PROJECT TITLE: Blanco - <sup>Lamp</sup> Shade Store ZONE ATLAS/DRNG. FILE #: 4-17 <sup>D22</sup> ~~22~~

*D22*  
**RE: RETAIL LAMP STORE (L17-~~17~~). DRAINAGE AND GRADING PLAN FOR  
BUILDING PERMIT APPROVAL. ENGINEER'S STAMP DATED APRIL 30, 1998.**

RE: Retail Lamp Store (L-17/<sup>D22</sup>~~17~~), Grading and Drainage Plan, Dated 3/24/98

RE: DRAINAGE PLAN FOR RETAIL LAMP STORE (L17-<sup>D22</sup>~~EE~~) ENGINEER'S STAMP  
DATED 3/24/98 AND ADDITIONAL INFORMATION SUBMITTED 4/16/98

Grading & Drainage Plan

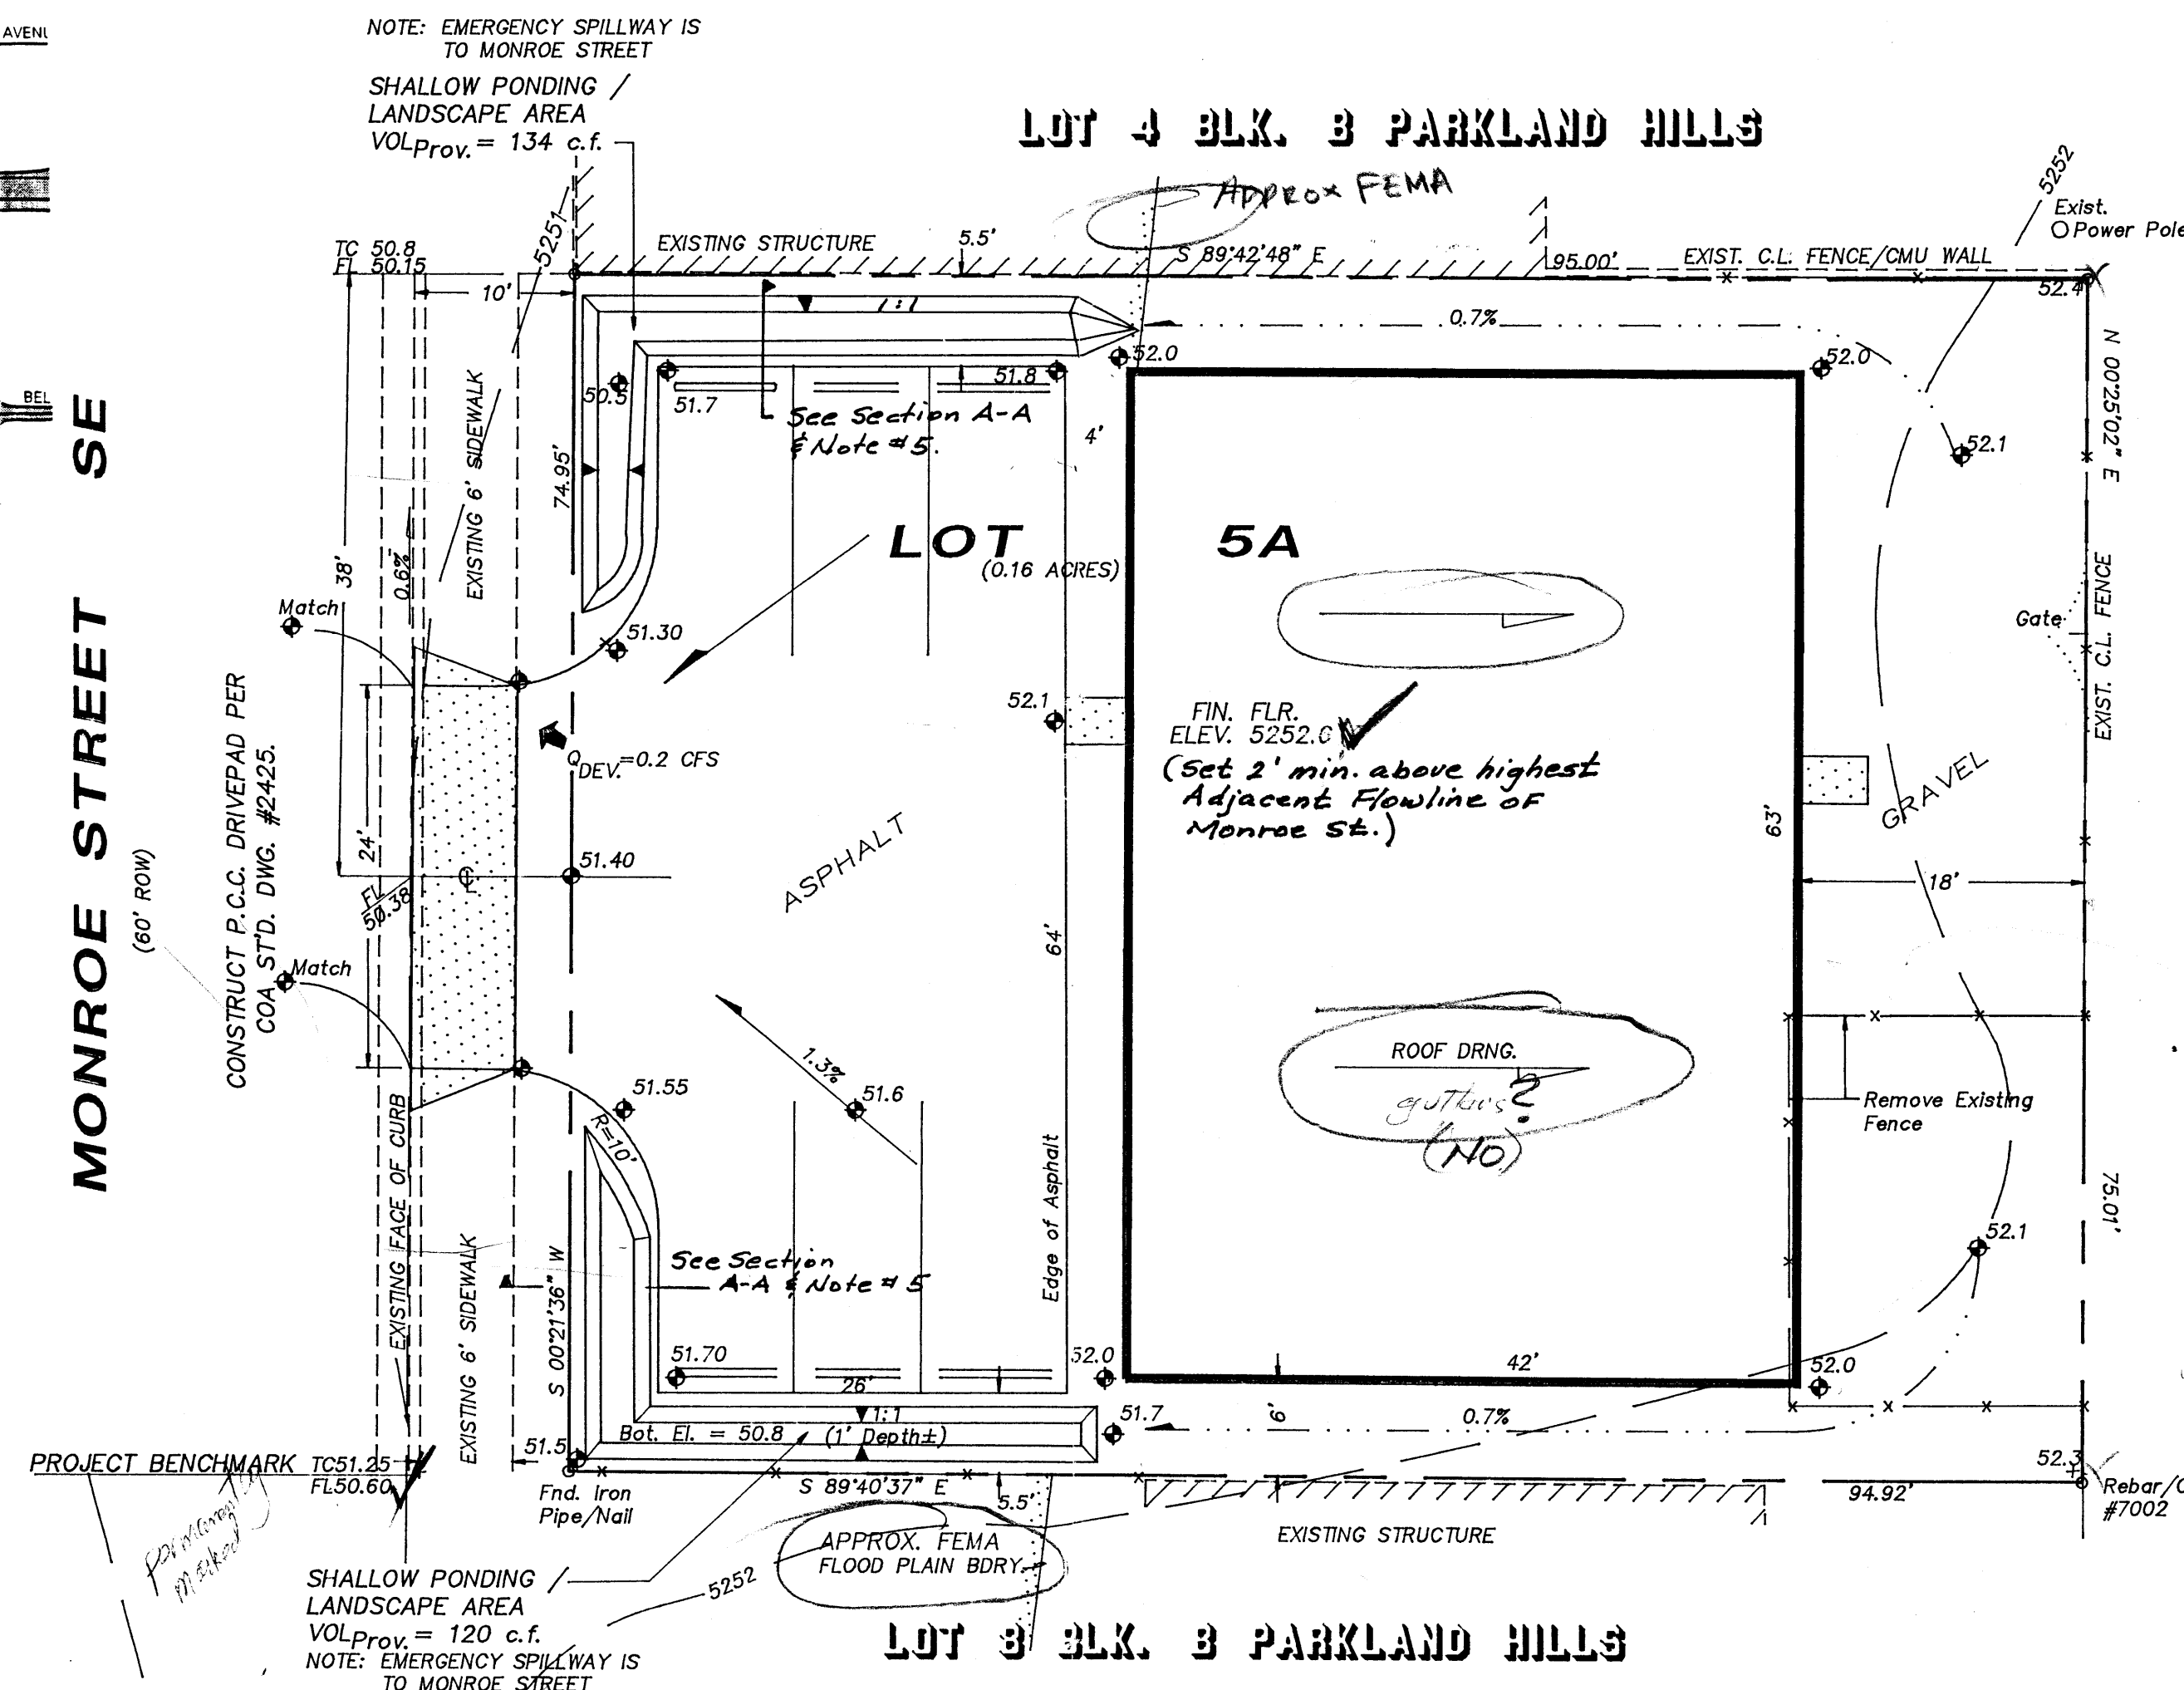
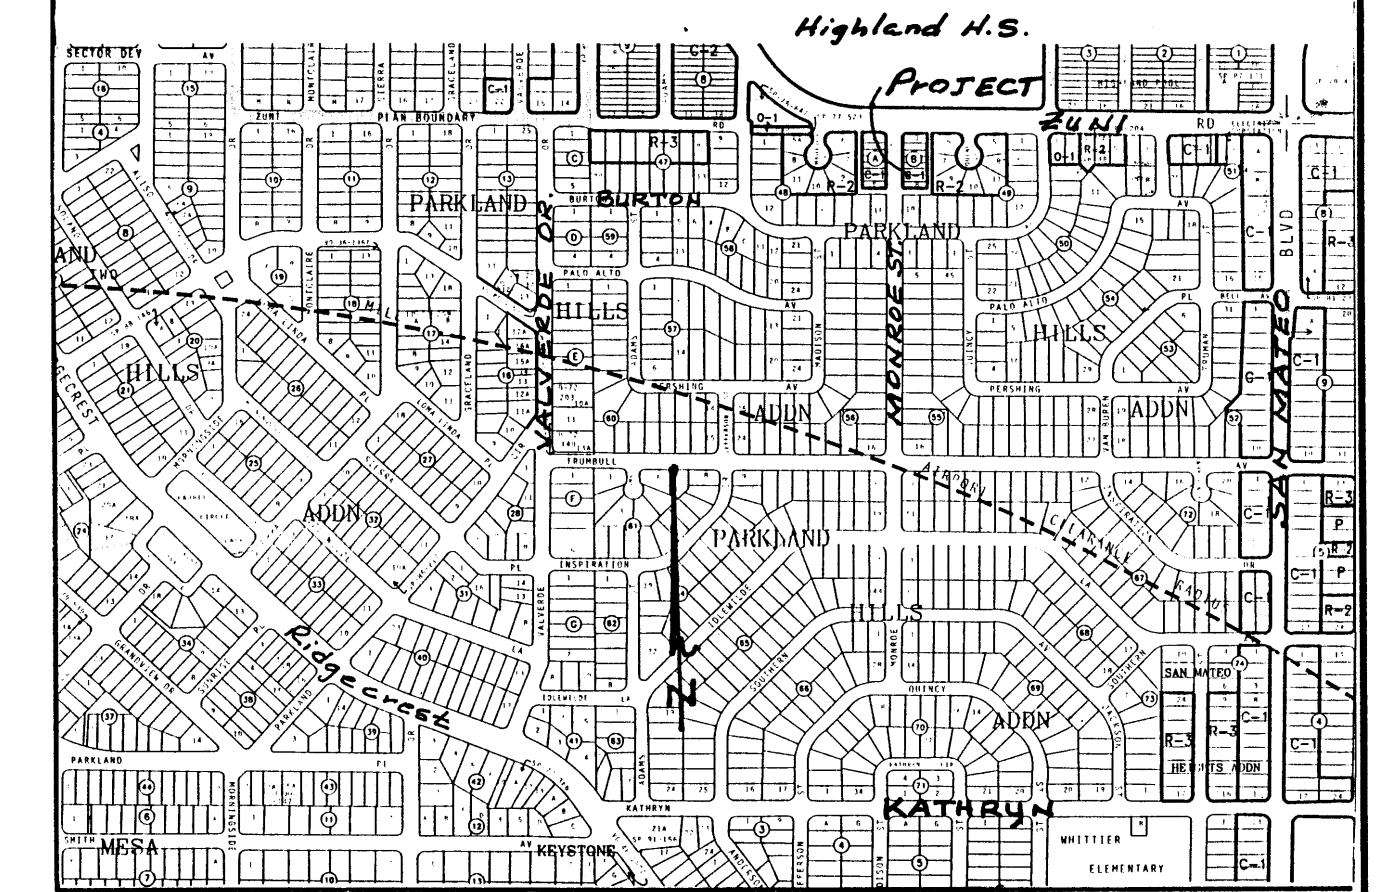
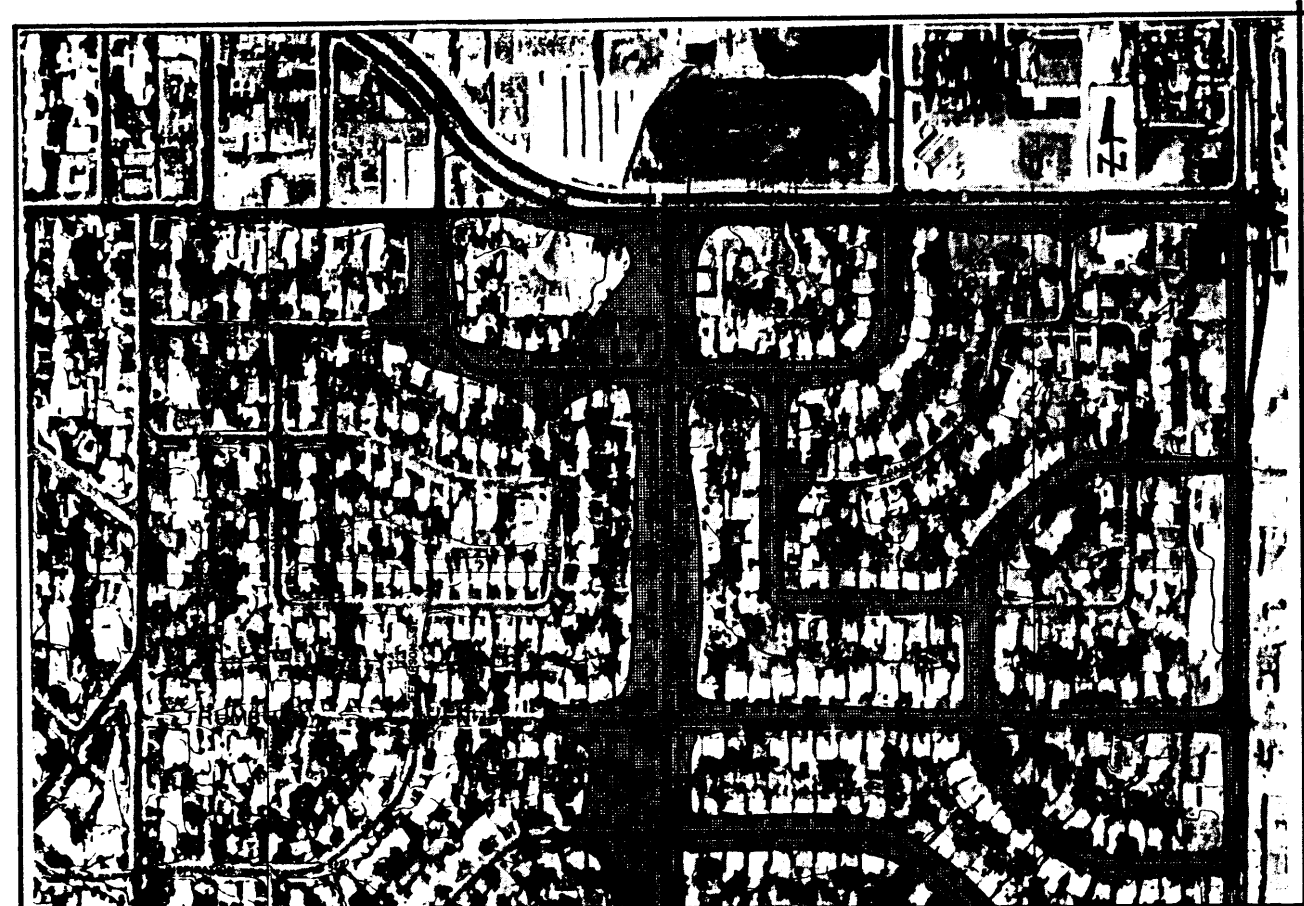
1. If you are going to use the alley to drain the developed run-off or to access the rear of the property, you will need to do alley grades and improvements. If a permanent barrier (6" curb ) is constructed on the east property line, than no alley grades or improvements will be required.

2. The ponds located at the front of the site can not receive developed flows. The swales around the building must have no less than 1.0% slope on the swale in order to guarantee positive drainage around the building the building and down towards the asphalt.

3. Indicate the approximate limits of the flood plain within the plan drawing through the total site.
4. Project bench mark must be permanently marked by a curb cut or painted.

5. Narrative on the plan drawing that the site is encroached by an AO-1' food zone and that flood insurance may be required.
6. Address off-site flows from all directions.

7. Indicate the existing & proposed flow rates and volumes on the plan drawing.
8. Remove the detention pond design note from the plan drawing.

9. Narrative on the plan drawing that the site is in an infill area and that the increase in the flows is minimal.

1. You must provide all relevant ponding calculations. The statement in Paragraph 4, under the heading "CALCULATIONS" is not sufficient.
2. Since the floodplain is not confined to the street, the flow line criteria may not be appropriate. Your finish floor elevation must be a minimum of 1-foot above the floodplain elevation. Since I was unable to find the elevation of the floodplain on your plan sheet, I could not tell if your finish floor elevation is set high enough.
3. Show limits of flood plain and floodplain elevation (to mean sea level). The floodplain cannot touch the structure.

- ✓ 1. Barrier curb added to plan at the east boundary (confirmed alternative solution via telecon with contractor).
- ✓ 2. Ponds deleted, depressed landscaped areas are redesigned, swale regraded to outfall across asphalt parking lot, note 5 revised to ensure no developed flows enter depressed areas.

- ✓ 3. Approximate limits delineated across site.
- ✓ 4. Existing old slash added to call out on plan. Will paint.
- ✓ 5. Narrative for AO-1 Flood zone including depth has been called out plan since the original plan submittal, please see "Grading & Drainage Plan", second paragraph.

- ✓ 6. Off-site flows addressed, second paragraph (inset), Existing Drainage Conditions.
- ✓ 7. Existing and developed data indicated within "Calculations" on the plan, and developed on drawing.

- ✓ 8. Design note removed.
- ✓ 9. As originally submitted, reference to "infill" within "Grading & Drainage" text, 1st paragraph.
